**Bradley Villa, Huddersfield
A641 Bradford Road Site Access Junction and Shepherds
Thorn Lane Ped/Cycle Access**

Response Report to Road Safety Audit Stage 1

July 2022 (Final)

PROJECT	BRADLEY VILLA, HUDDERSFIELD
DRAWING TITLE	A641 BRADFORD ROAD PROPOSED SITE ACCESS ARRANGEMENT

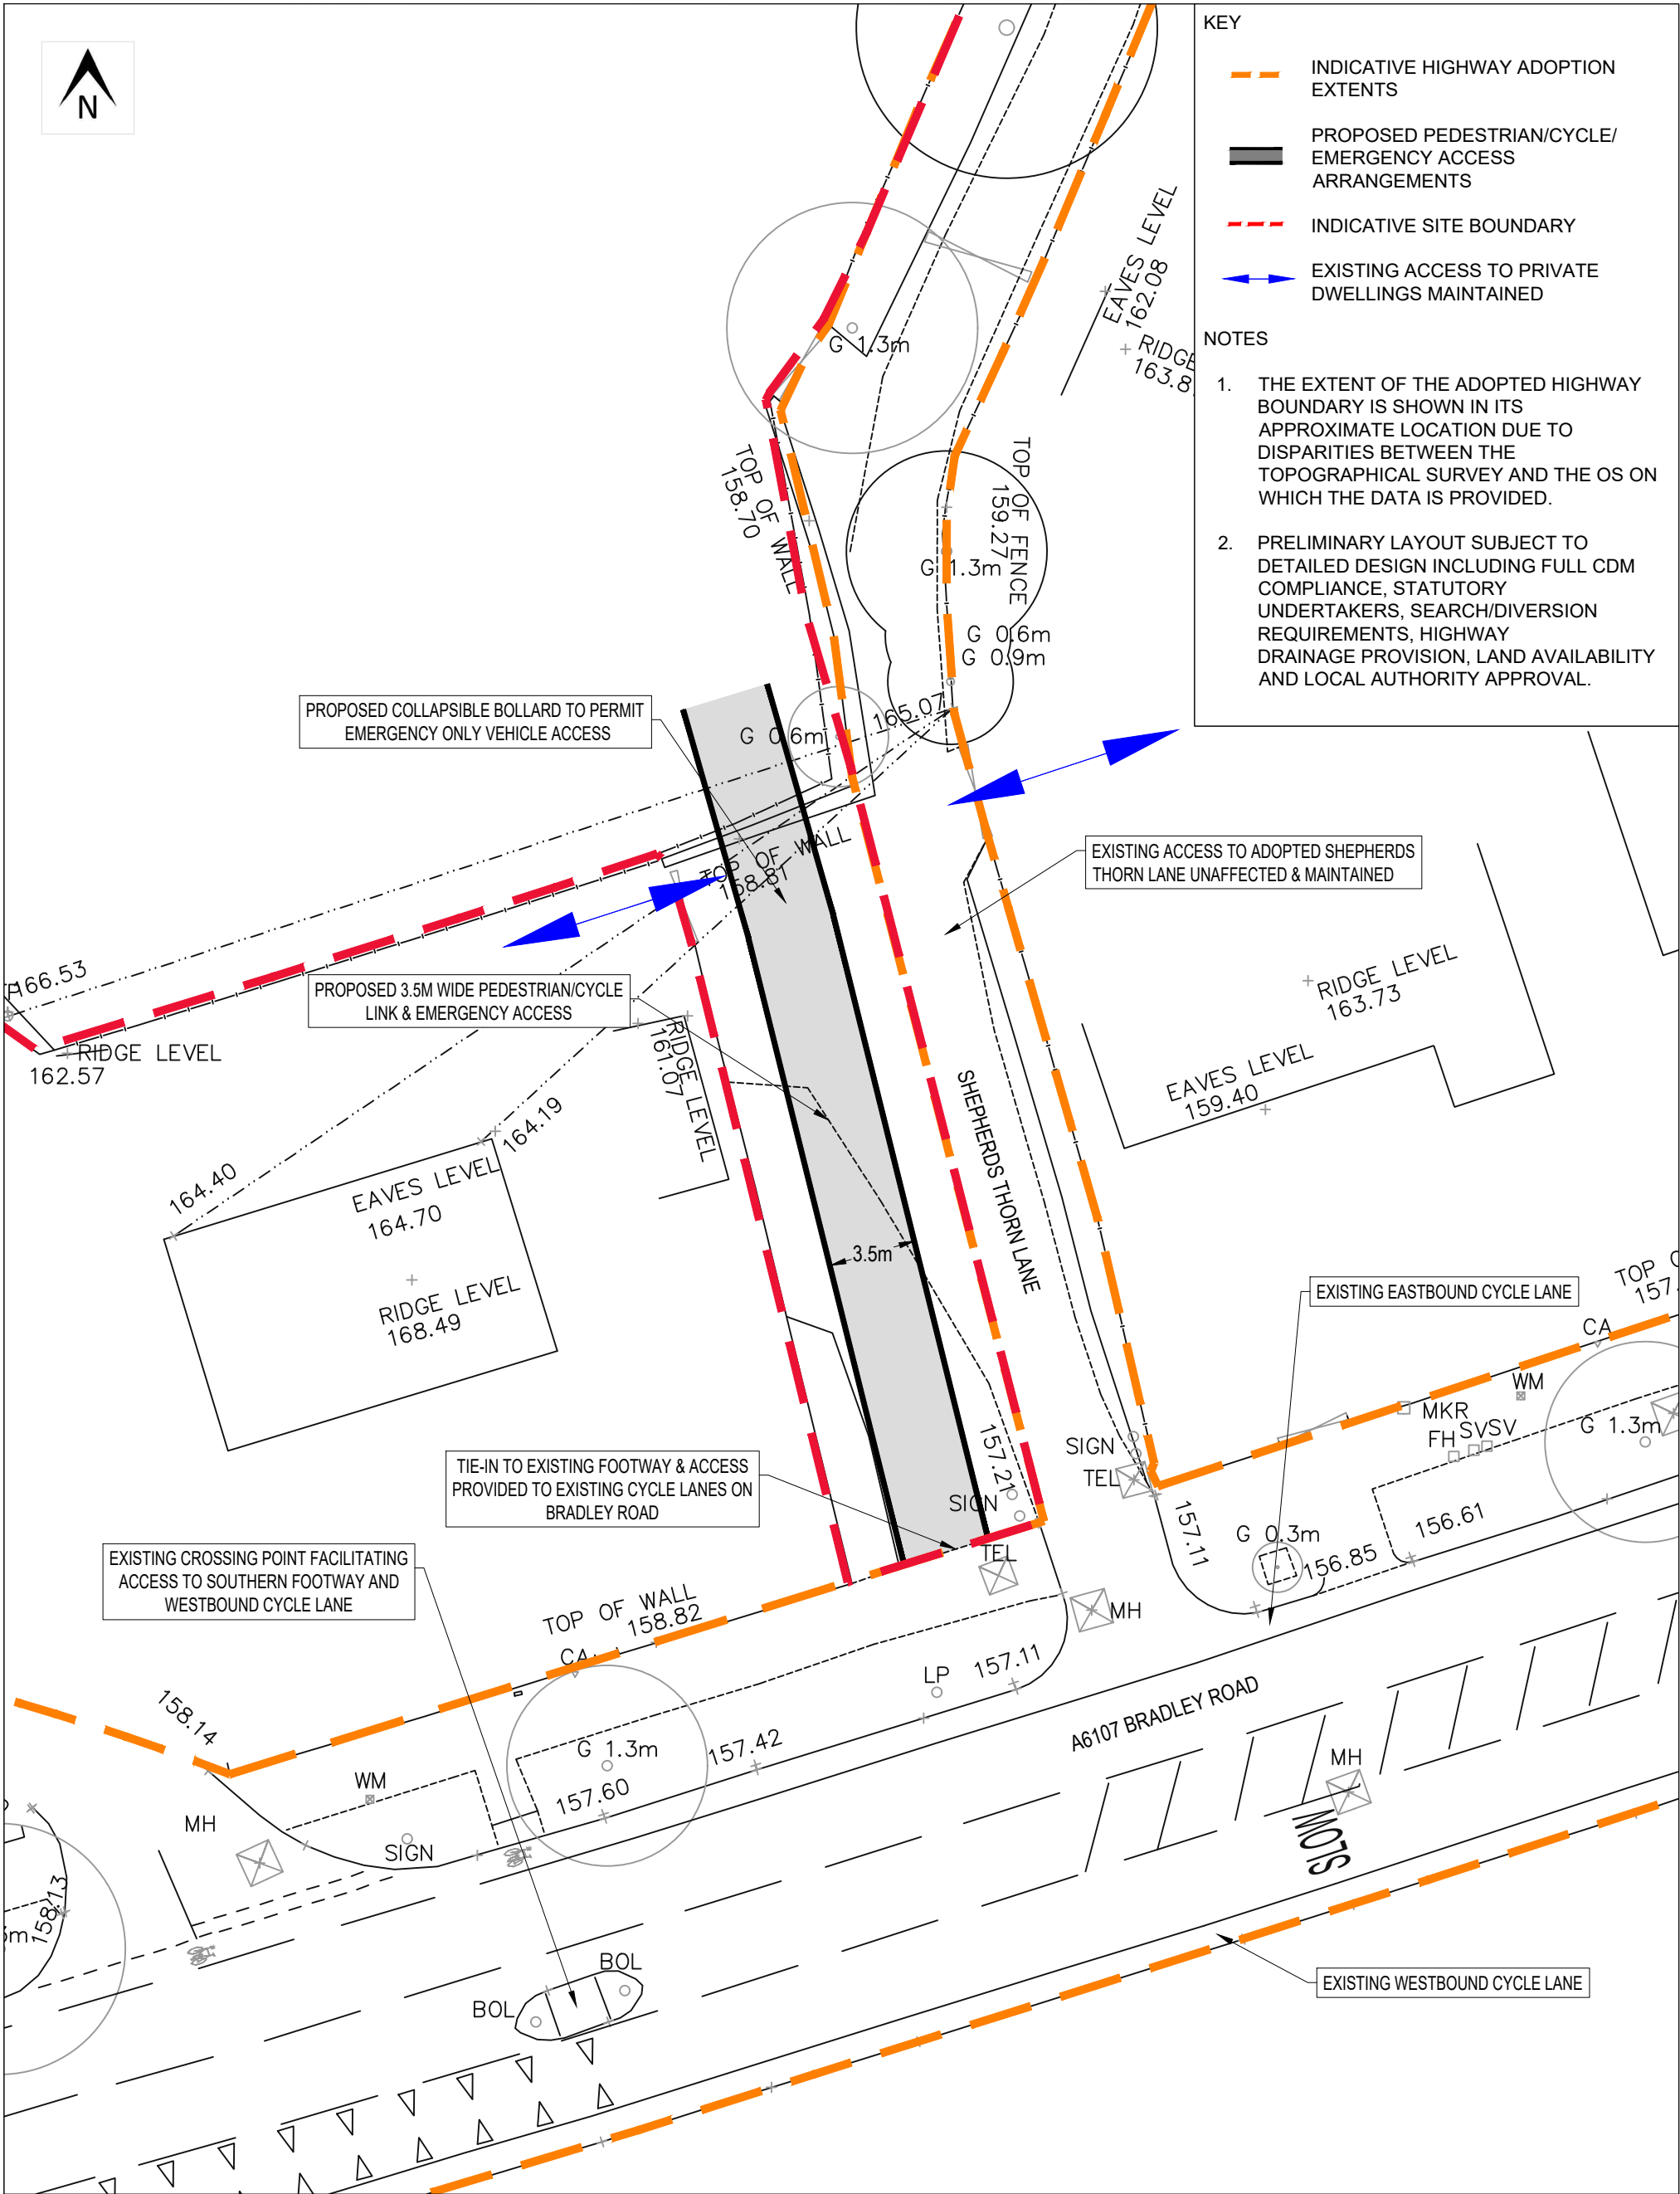
2.1 Problem: Proposed Right Turn Visibility Obstructed Location – A641 Bradford Road proposed right-turn lane into Site access junction Summary – Sight line for right turning vehicles potentially obstructed by the crest of the hill and bend in the road. Detail – The vertical alignment and bend in the road towards the left obstruct visibility for drivers turning	A visibility splay assessment should be carried out (potentially including a speed survey) to establish if adequate visibility is provided. In addition, it is recommended that the orientation of the “Left Turn Only” sign be made clear on any design drawings.	The RSA recommendation is accepted and a long section drawing has been produced to confirm the level of visibility for right turning vehicles, as shown on the drawing attached at Appendix C. It was requested by the Council that an updated speed survey was undertaken along the A641	The long section drawing (19154/IN/05) indicates that a 120m sightline is available for right turning vehicles, when measured to an object height of 1.05m. However, based on further on-site observations by Kirklees HDM, it is clear that views to an approaching southbound vehicle	The drawing attached at Appendix C includes the following amendments: • Toucan crossing has been relocated to the south of the Site access out of the visibility envelope for right turning vehicles – The final

RSA Problem	RSA Recommendation	Design Organisation Response	Overseeing Organisation Response	Agreed RSA Action
3.1.1 Problem: Central Island at priority junction may encourage right turns Location – Centre of proposed site access / A641 priority junction. Summary – Proposed arrangement of give-way central island and central reservation may encourage vehicles to turn right through the right-turn lane. Detail – The proposed drawing shows the give-way central island and central reserve along A641 Bradford Road. The arrangement may encourage (and physically still allow) drivers exiting the site to illegally turn right through the adjacent right-turn lane in order to avoid having to route southbound towards the Bradley Bar Roundabout and back north again. This will result in vehicle conflict and collisions.	It is recommended that the designs of the proposed site access junction give-way central island and A641 Bradley Road central reservation are amended to make the aforementioned dangerous manoeuvre as difficult as possible.	The RSA recommendation is noted, and amendments have been made to the central reserve as shown on the drawing attached at Appendix C. The vehicle tracking drawing contained at Appendix E has also been updated to reflect the changes made.	The original layout already discourages right turn movements from the site access, through the provision of a deflection island on the minor arm, an extended central island adjacent to the right turn lane and the provision of the left turn only sign. Whilst the suggested extension of the central island would further discourage right turns from the site access, it also restricts the right turn movement into the access, which would be extremely constrained for large vehicles and this could result in overrunning of the islands. Therefore, the suggested alteration is not accepted. Due to vehicle swept path requirements on the minor arm, it does not appear possible to increase the size of the deflection island further as an alternative option. Therefore, it is instead suggested that additional left turn only text and arrow road markings are provided on the site access exit to reinforce the turning restriction at the junction.	Alterations to the design to make the right turn out of the Site access 'as difficult as possible' is not accepted. The layout already discourages right turning traffic out of the Site access and any extensions to kerb lines would be problematic for large vehicles manoeuvring into and out of the Site access. The agreed action is to provide additional left turn only text and arrow markings on the Site access to reinforce the turning restriction at the junction – as shown on the drawing attached at Appendix C.

3.2.1 Problem: Visibility to the right restricted due to vertical alignment, traffic signs, bend in the road Location – Proposed site access junction give-way Summary – Visibility from the minor road is potentially restricted due to the crest of a hill, traffic signs and bend in the road Detail – The Audit team noted that the vertical alignment of the A641 Bradford Road north of the proposed site access junction could result in restricted visibility. No information is provided on Drawing No. 19154/GA/01 as to whether the 2.4m x 120m junction visibility splay can be achieved in the vertical plane due to the existing crest in the road. As a consequence of the above, there is the potential for vehicles exiting the site to be struck by oncoming vehicles travelling at speed if adequate visibility is not provided.	It is recommended that the design team assess whether the visibility to the north from the site access is achievable in the vertical plane or not. If not, then an alternative form of junction control may be necessary. A visibility splay assessment should be carried out (potentially including a speed survey) to establish if adequate visibility is provided.	The RSA recommendation is noted and it is advised that the long sections have already been completed and accepted by the Council after being included within TA Addendum 2 dated April 2022. A copy of the long sections are attached at Appendix F for completeness and show that appropriate visibility can be achieved in the vertical plane.	The long section drawing (19154/IN/03) indicates that a 120m visibility splay is available to the north from the site access, when measured to an object height of 1.05m. However, as with problem 2.1, due to the vertical alignment (crest) of the carriageway, only the tops of cars/bikes will be visible at the full 120m SSD. Therefore, careful siting of any signage or other features in the highway verge/footway to the north of the junction is required, to ensure that the visibility/ conspicuity of the junction is unaffected, with a full review of existing / proposed signage	Careful siting of any signage or other features in the highway verge/footway to the north of the junction is required, to ensure that the visibility/ conspicuity of the junction is unaffected, with a full review of existing / proposed signage required at the detailed design stage, and additional/ amended warning signage and road markings provided as necessary.

RSA Problem	RSA Recommendation	Design Organisation Response	Overseeing Organisation Response	Agreed RSA Action
<i>right into the proposed site access junction. The proposed crossing facility, and pedestrians / cyclists using the same will add to the potential obstruction of vehicles approaching at high speed. This may encourage drivers to 'peep and creep' into the opposite side of the road where there is potential for collisions with southbound traffic travelling at speed. It is also noted that the proposed drawing states 'provide 'left turn only' sign' but the orientation of the sign is not clear (it would be assumed to face traffic leaving the site access.</i>		Bradford Road. The speed survey was undertaken on 17th November 2021 in wet weather conditions. The results of the survey are attached at Appendix D and the northbound (NB) and southbound (SB) 85th percentile speeds are summarised below: • NB – 35mph; • SB – 36mph; • NB adjusted – 40mph; and • SB adjusted – 41mph. Given that the speed survey was undertaken in wet weather conditions an additional 8kph has been added to the recorded 85th percentile speeds, in accordance with paragraph 3.1.1 of DMRB document CA 185 'Vehicle Speed Measurement' for dual carriageways. The survey demonstrates that vehicular speeds comply with the prevailing 40mph speed limit in place along the A641 Bradford Road (or very marginally above in the case of southbound movements), adjacent the Site access junction.	will be obscured due to the vertical alignment (crest) of the carriageway, which is exacerbated by the proposed toucan crossing (both the apparatus and waiting pedestrians/cyclists) and overgrown verge within the central reservation (on both sides of the Dorchester Road junction), with only the tops of cars/bikes being visible at the full 120m SSD. Therefore, improvements to forward visibility will need to be incorporated at the detail design stage. The toucan crossing will also need to be relocated as this is likely to have an unacceptable impact on visibility and make the waiting right turning vehicle inconspicuous to approaching southbound drivers. Measures to improve visibility and conspicuity associated with right turning vehicles must be incorporated at the detailed design stage. The following measures are suggested and should be shown indicatively on the preliminary layout as follows:	location of the crossing to be determined at the detailed design stage, with crossing located to maximise separation/stacking space from Bradley Bar Roundabout; • Verge in central reservation that is within the visibility envelope has been shown as hard surfacing; • A note has been added to the drawing setting out that street furniture/trees in central reservation either side of Dorchester Road junction, within the visibility envelope, are to be removed/relocated where possible; and • A note setting out that warning signage is to be provided and SLOW road

RSA Problem	RSA Recommendation	Design Organisation Response	Overseeing Organisation Response	Agreed RSA Action
			- Toucan crossing relocated from sightline; - Verge in central reservation either side of Dorchester Road junction that is within the visibility envelope to be replaced by hard surfacing; - Street furniture/trees in central reservation either side of Dorchester Road junction that is within the visibility envelope to be removed/relocated where possible (e.g. excluding any statutory signage etc that may be necessary). - Warning signage and SLOW road markings to be provided on southbound approach (e.g. replacement of the bend ahead sign with junction on bend ahead sign). - Vertical alignment of right turn lane carriageway designed to maximum available visibility.	markings have been shown on the southbound approach. All of the above measures will assist in maximising the available visibility for right turning vehicles as part of the detailed design process.
